Western Sydney Parklands Trust

Re: Response to Public Authority Comments for Light Horse Interchange Business Hub, Easter Creek - SSD9667

Attachment A – WSPT’s response to Public Authority Comments for Light Horse Interchange Business Hub and updated Concept Masterplan

Figure 4 – Biodiversity Corridor Widening Investigation Area (Source: Ecoplanning)

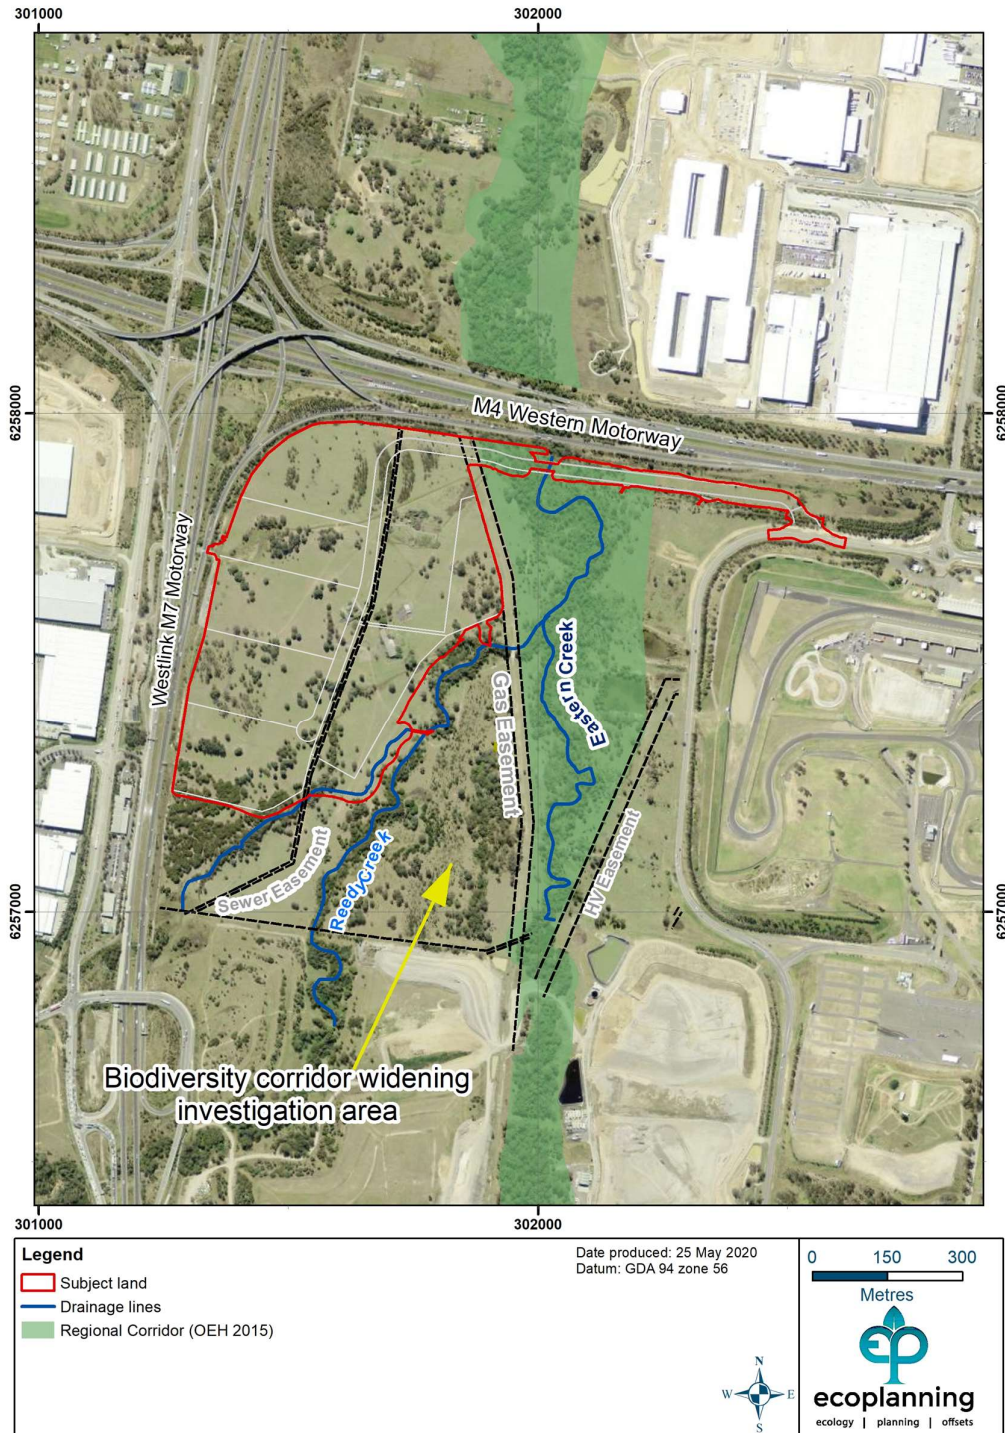
Environment, Energy and Science Group (EES)	
Item	Response
<p>While widening the corridor at this location may have its merits, Figure 4 in the RTSA only refers to it as a “biodiversity corridor widening investigation area” (page 29). This implies it is not definite that the ‘investigation area’ will be added to the corridor. Greater certainty is required, particularly as the investigation area is located outside the subject site and it is unclear whether it is in the same ownership as the SSD site. If the investigation area is not added to the corridor, the opportunity to widen the Bushland Corridor within Precinct 6 at the SSD business hub site would be lost once the SSD is approved. Details are required as to whether the investigation area site is in the same ownership as the proposed SSD site, otherwise the proposed investigation area is irrelevant. The proponent should focus on what can be delivered on the subject site.</p>	<p>The proposed Business Hub and the proposed Bushland Corridor widening investigation area are both located within Lot 10 in DP1061237. This land is in Western Sydney Parklands Trust ownership.</p>
